2023/0024

Increase in roof height to enable conversion into dormer bungalow with new front and rear facing dormers, single storey extensions to the side/rear with associated under-build below the rear extensions and first floor rear balcony.

5 Castle Drive, Hood Green, Barnsley, S75 3EY

PROJECT Extensions & Alterations  
 CLIENT Mr. & Mrs. Craig Fisher  
 TITLE Elevations as Proposed  
 ADDRESS 5 Castle Drive, Hood Green, Barnsley. S75 3EY  
 DRAWN BY 999  
 SCALE 1:100 © A3 DATE Nov 22  
 DRAWING No 983-04 REV B  
 Member of the Chartered Institute of Architectural Technologists

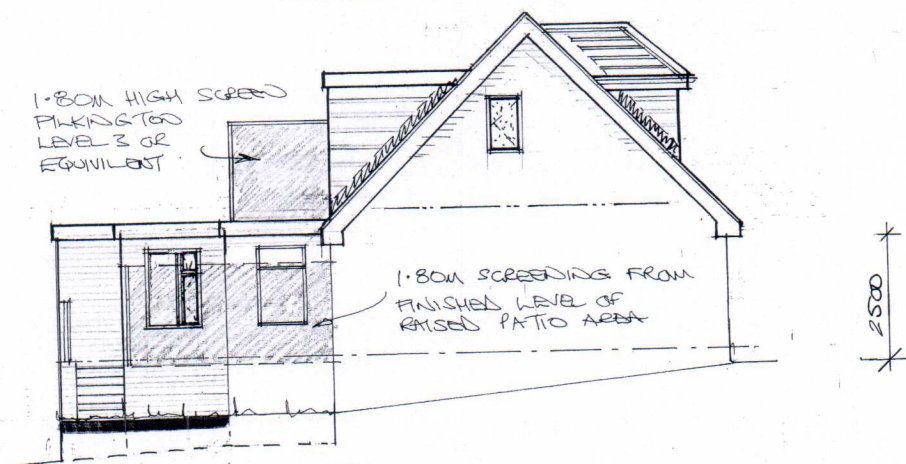
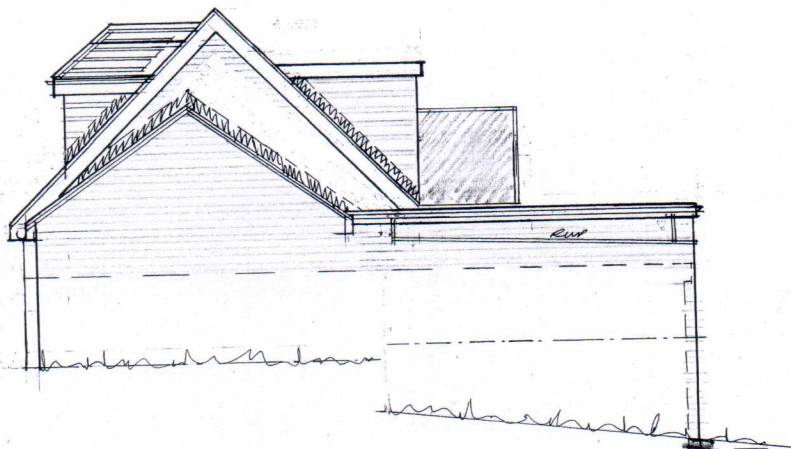
The plans have been amended during the determination of this application. The original plans included a front porch extension, which has been removed, there has also been some alterations to the design of the rear extension and rear dormer which was original built off the rear wall.

As mentioned previously the plans have been amended during the determination of this application. The amendments, whilst minor, have seen the removal of the front porch extension and alterations to the design of the rear dormer window which was originally built off the rear wall of the dwelling.

Supplementary Planning Document – House Extensions and other Domestic Alterations states that the design of dormer windows should reflect the character of the area and the surrounding buildings. Usually, vertically proportioned dormer windows with pitched roofs are traditionally found in the Barnsley area. The style of dormer proposed, with hipped roofs, are characteristic of the area and is evident in the neighbouring dwelling and the surrounding properties. It is acknowledged that the rear dormer is designed with a flat roof; however, it is located within the rear roof plane and not highly visible from public vantage points and its design provides a modern contrast to the typical 1960s bungalow. It is also worth noting that a flat roof horizontally proportioned rear dormer of the same dimensions could be erected under permitted development as set out in the Town and Country Planning (General Permitted Development Order) 2015 (as amended).

The proposed side extension is designed with a pitched roof; it is acknowledged that it is a different pitch to the main dwelling, however, the extension remains subordinate to the original dwelling and given the dwellings position within the street scene would not result in a prominent feature within it. In addition, it would replace a flat roof, which is visually at odds with the pitched roof dwelling.

Again, the rear extensions are designed with a flat roof, however the eaves of the extensions are compatible with main dwelling and the rear elevation is not visible from public vantage points, and a single storey rear extension with a similar design could be erected under permitted development.

The extensions are to be constructed from materials to match the original dwelling, red brick, however no materials have been specified in relation to the proposed dormer windows and as such it is considered prudent to include a condition relating to their proposed materials.

It is proposed to install dormer windows to both the front and rear elevations and do not project closer to their respective boundaries than the original dwelling. It is acknowledged that it is proposed to utilise the roof of the existing rear projection as a balcony, given that open green belt is located beyond the rear boundary, it would not increase levels of overlooking to the rear. It is acknowledged that the balcony and the raised patio could increase levels of overlooking of the neighbouring properties, particularly 6 Castle Drive. However, the neighbouring dwelling is located approximately 2m from the eastern corner of the application property, with the balcony and the raised patio to have 1.8m obscurely glazed screening to the relevant elevations; the 1.8m is to be measured from the floor level of the respective elements. This is considered sufficient to limit increasing levels of overlooking of the neighbouring dwellings without reducing levels of outlook.
